# DRB CASE ACTION LOG (SITE PLAN B.P.)

Project Name BRENTWOOD HILLS

**RE:** **PROJECT NO. 1001740, Case Number 05DRB – 00823, Global Storage – Candelaria & Chelwood Park.**

Re: Global Storage, 12000 Candelaria NE  
Project # 1001740\*

SITE DEVELOPMENT PLAN

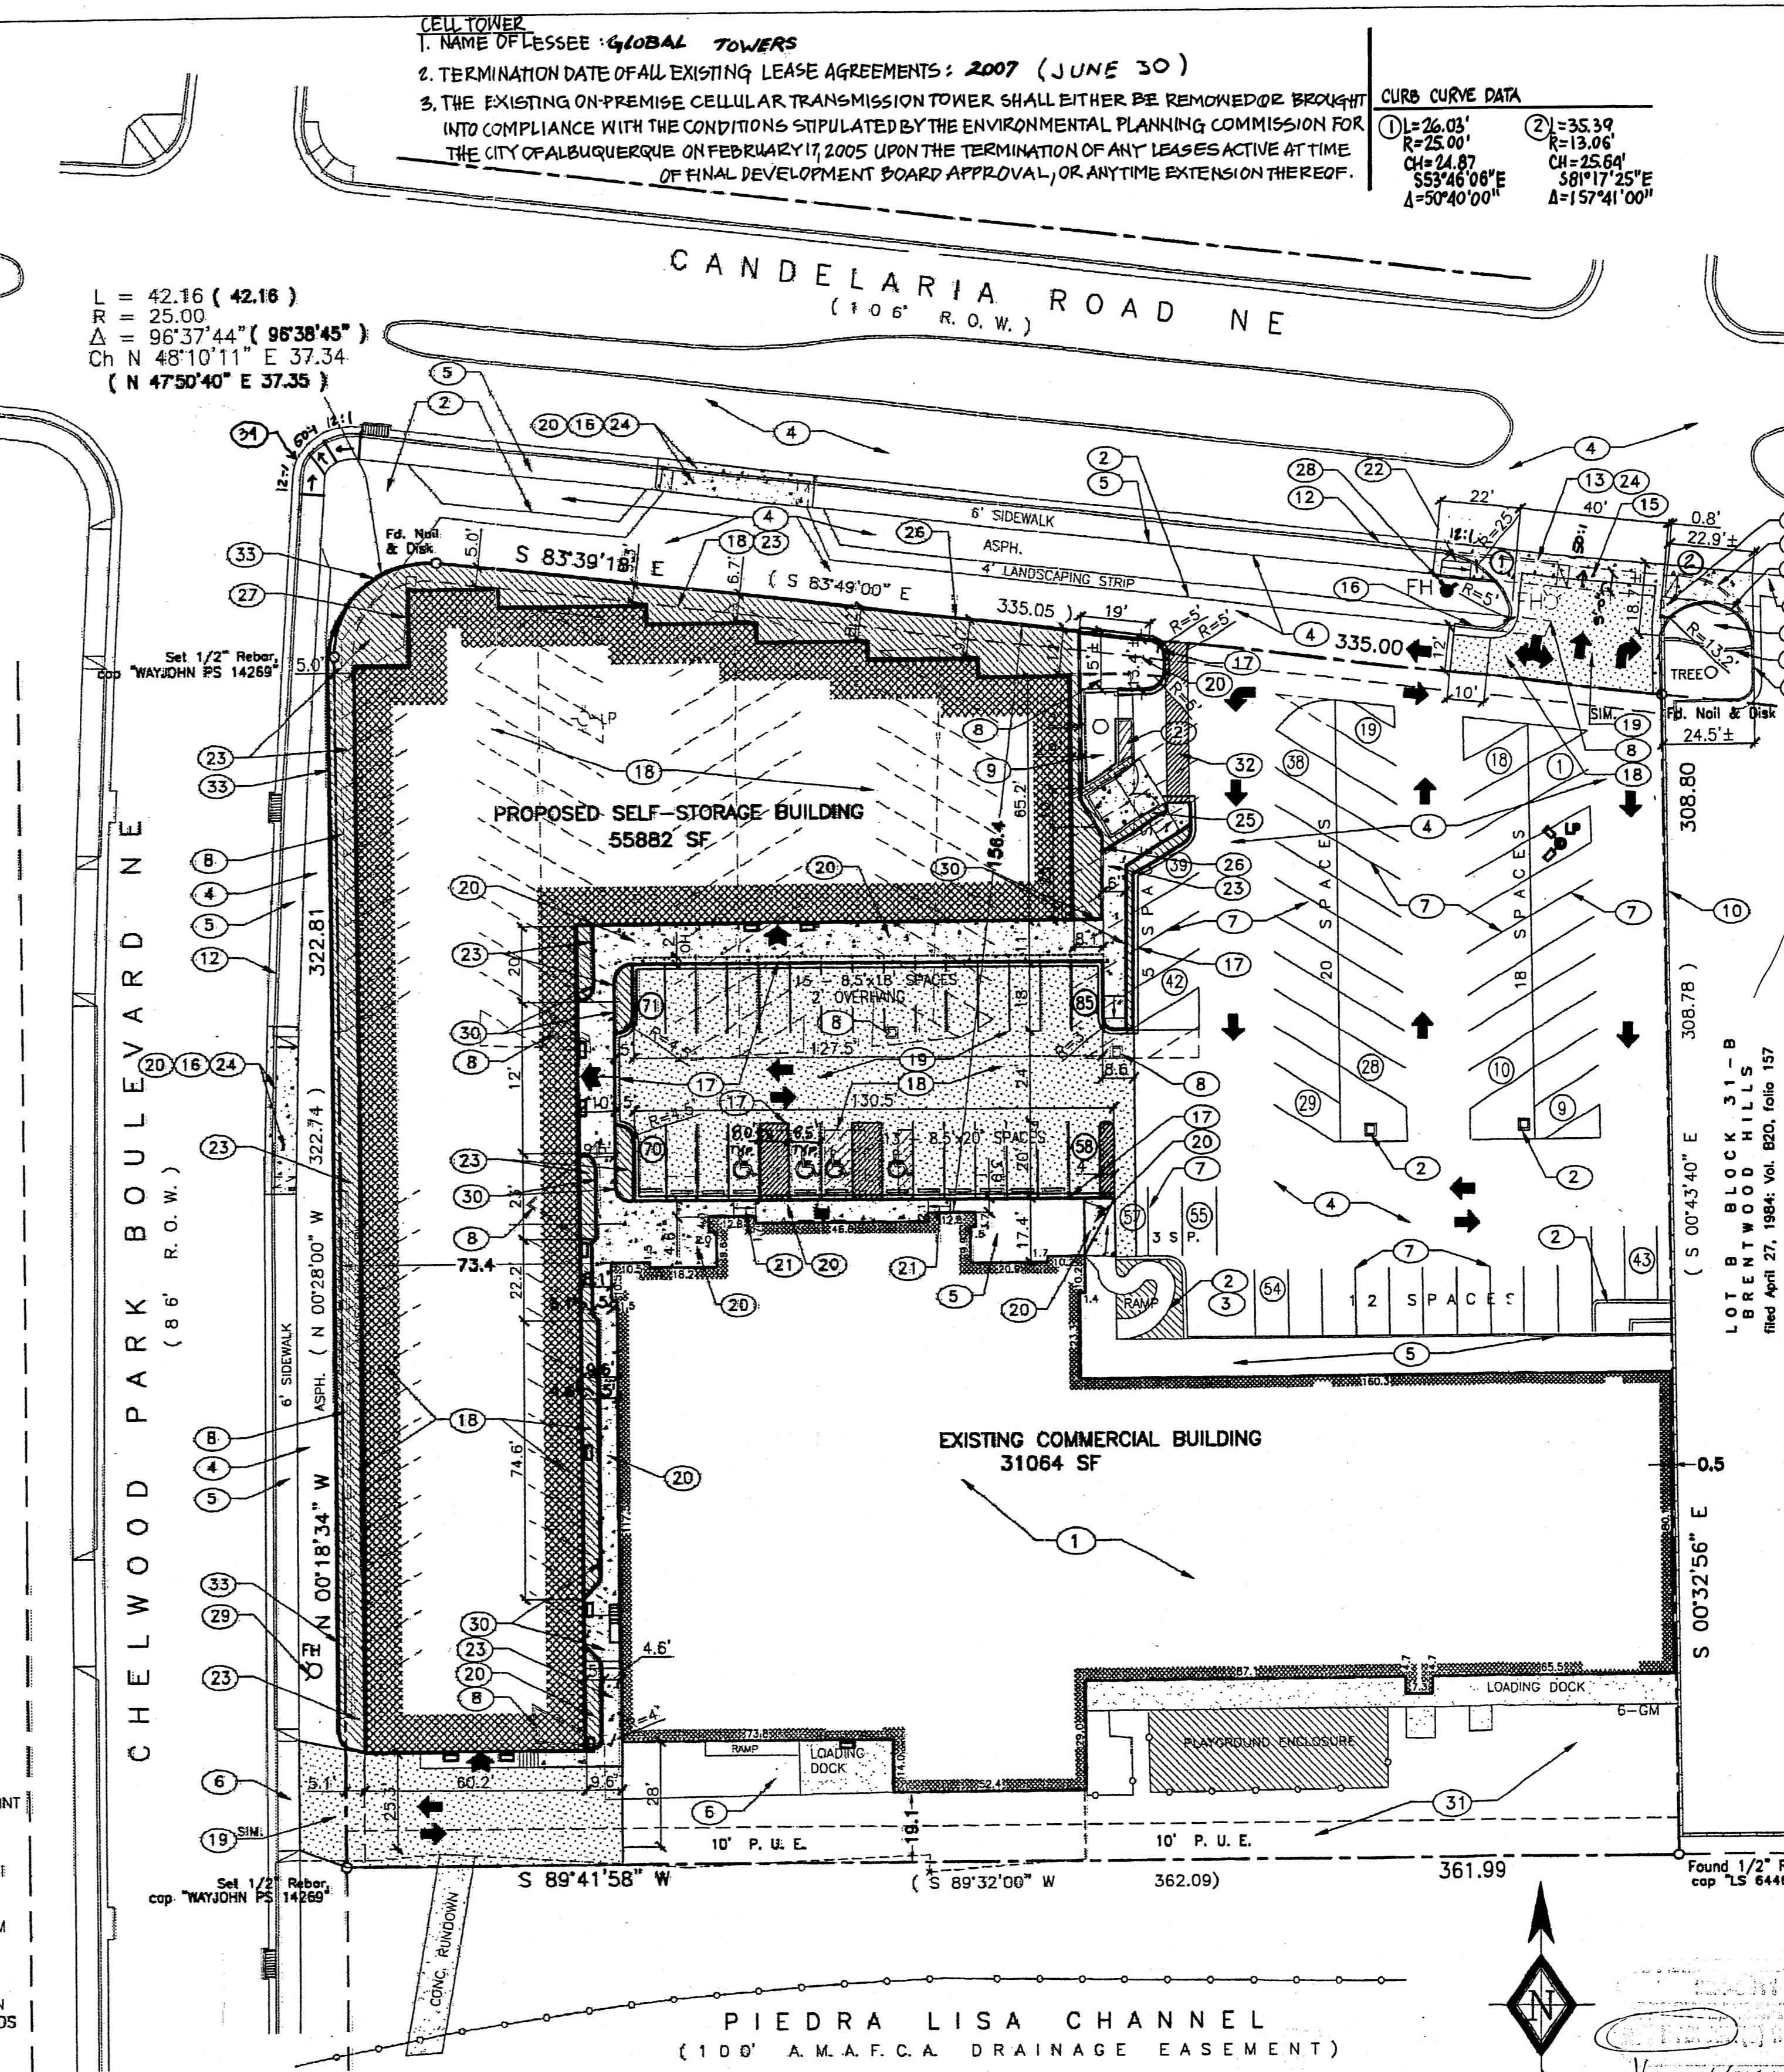
- UTILITIES: revise Utility Plan to show fire hydrants
- eliminate new 1" meter eliminate sewer connection
- shown. Only new item is 6" fire line.
- \_\_\_\_\_
- \_\_\_\_\_

1 WEST ELEVATION (CHELWOOD ELEVATION)
A1 SCALE: 1/8" = 1'-0"

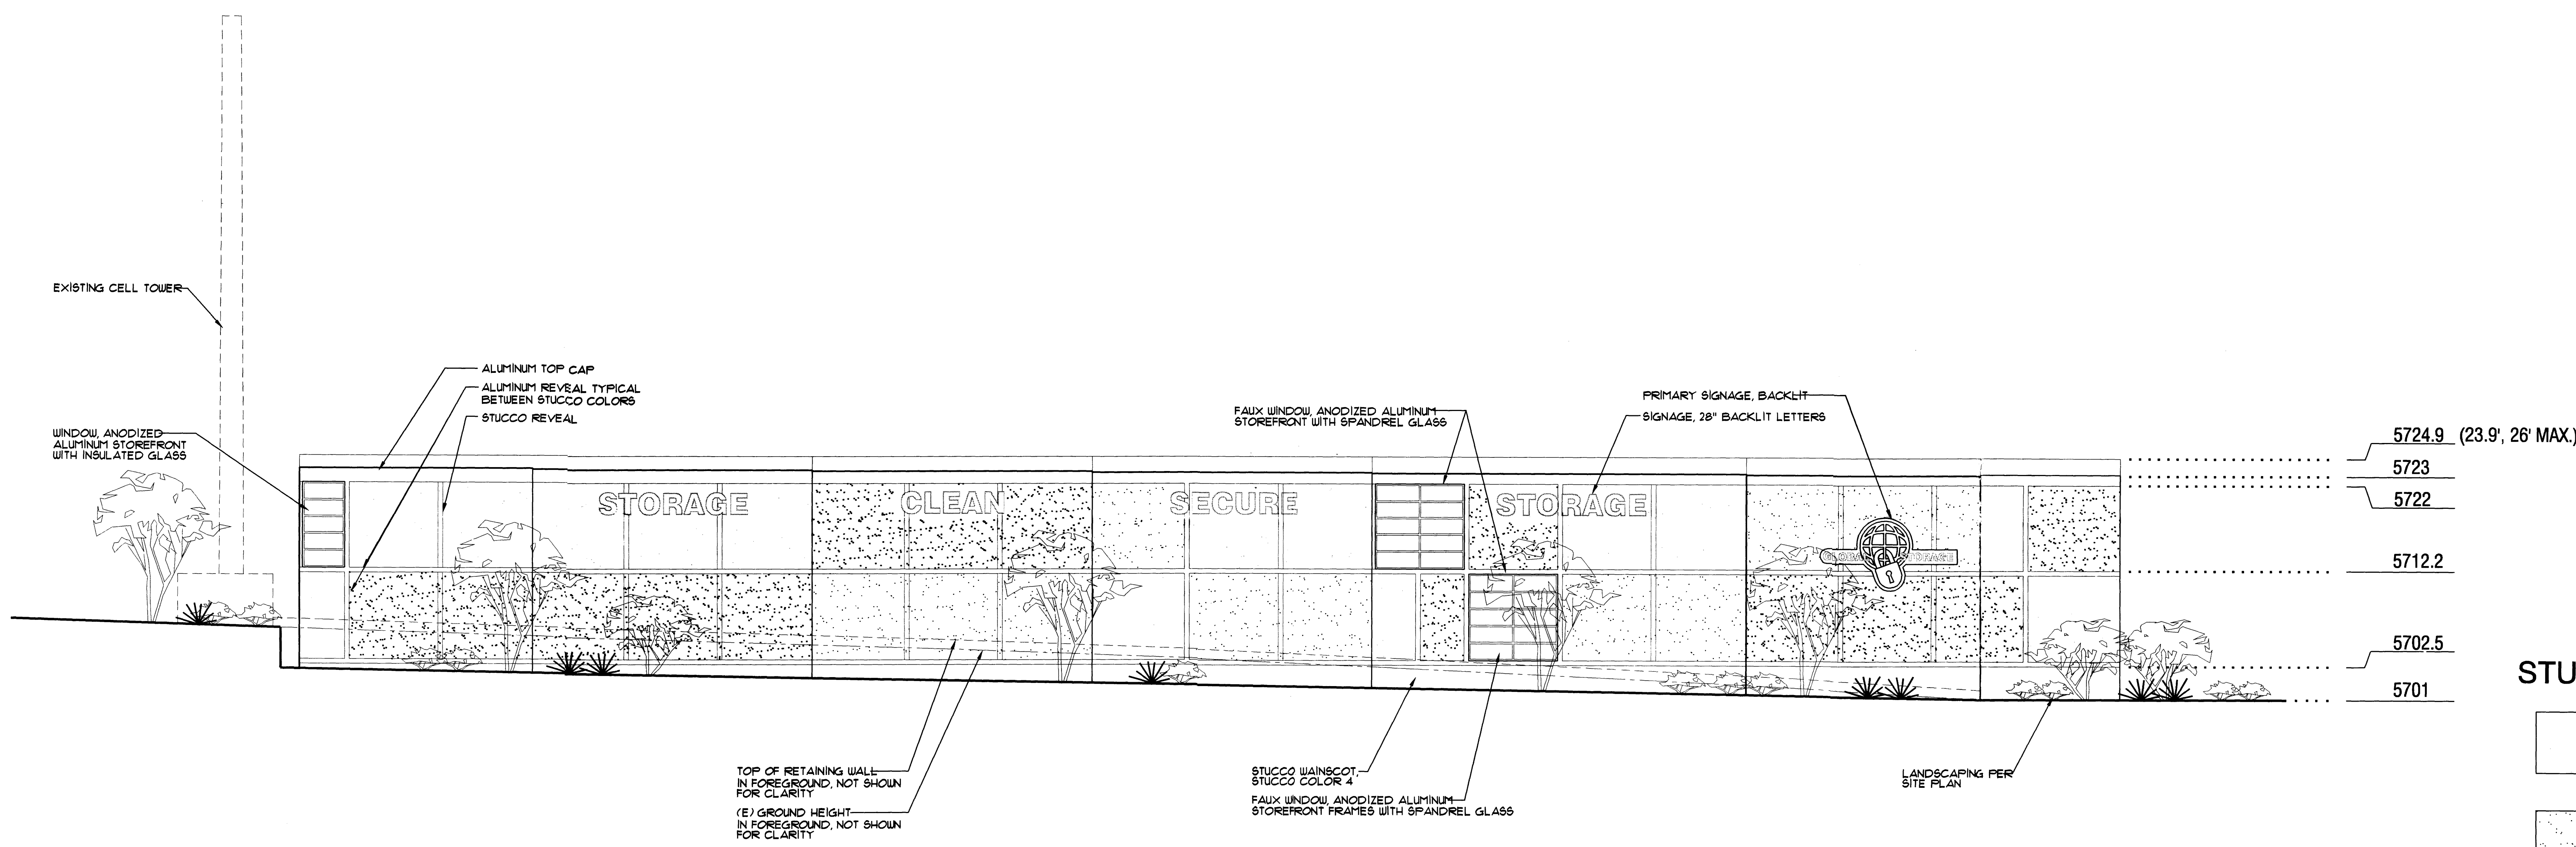
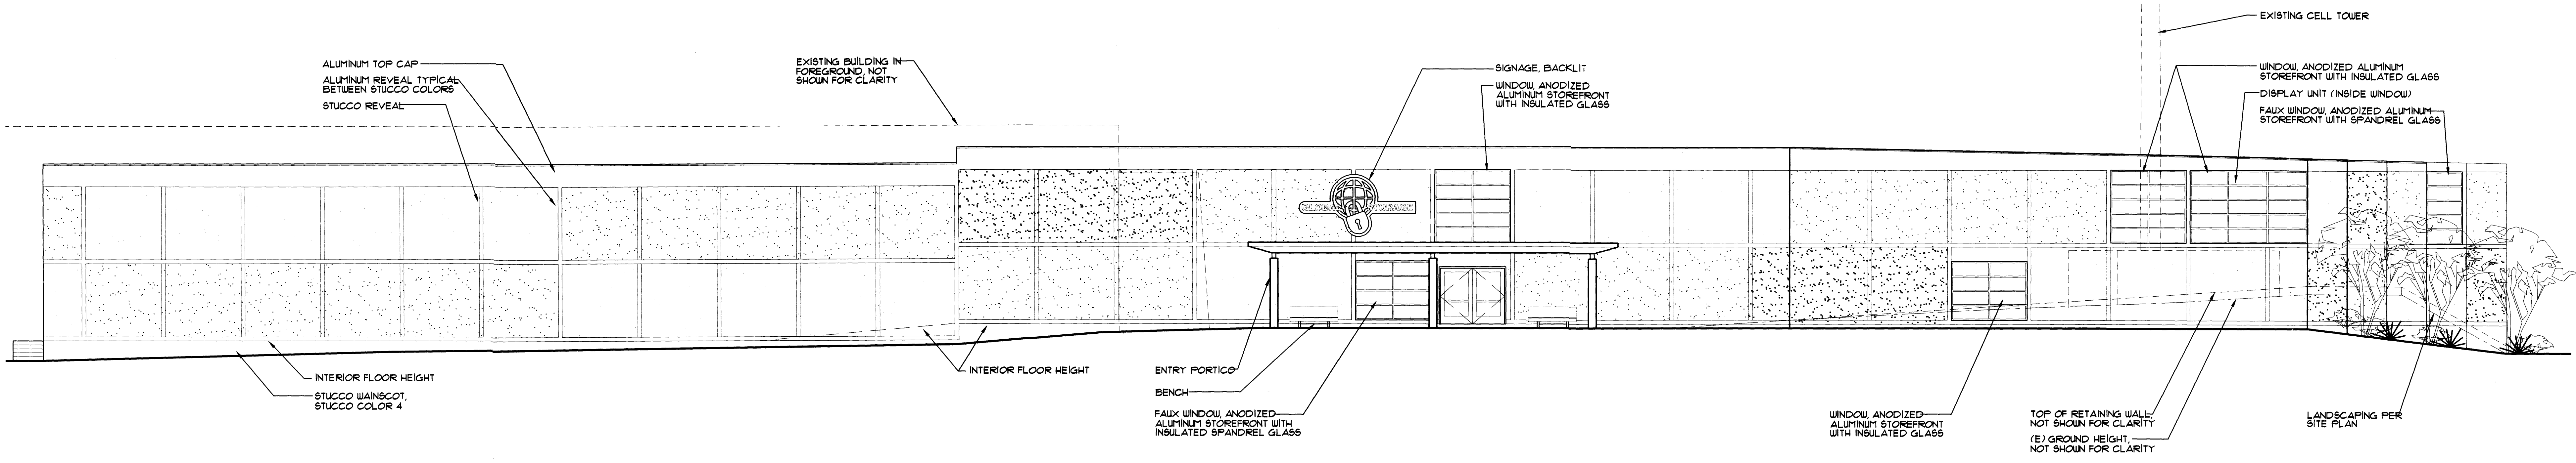
9. *The applicant shall be required to include pilasters spaced every fifty feet (50') along each façade that is greater than 100 feet in length. At least two faux window treatments containing mullions will be installed between interceding pilasters. See comments below.*

10. *The applicant shall include wainscoting around the building where the material and color are complementary to the overall building. See comments below.*

Comments: There are substantive changes to the proposed exterior design of the new building. Upon further examination, I do not believe that the changes warrant an administrative amendment to the EPC-approved site plan as the changes do not affect overall building size or footprint or internal site circulation, as outlined in §14-16-2-22-A-6 of the Zoning Code. Among the changes noted is the inclusion of aluminum and stucco reveals, alternating stucco textures and coloring, and different storefront glass pane treatments. It is noted, however, that the proposed color of the wainscoting is not

included, although it is referred to in the elevations (Color number four [4]?). This needs to be clarified. Additionally, I would prefer to see more faux window treatments, or strategically paced groupings thereof, along both the Candelaria and Chelwood Park elevations; although the new proposed exteriors are significantly better than the original proposal, some more window treatments will offer some relief, given its scale and massing. Given the staggering along Candelaria, emphasis should be given to the Chelwood Park elevation, although some window treatments along Candelaria would not be discouraged.
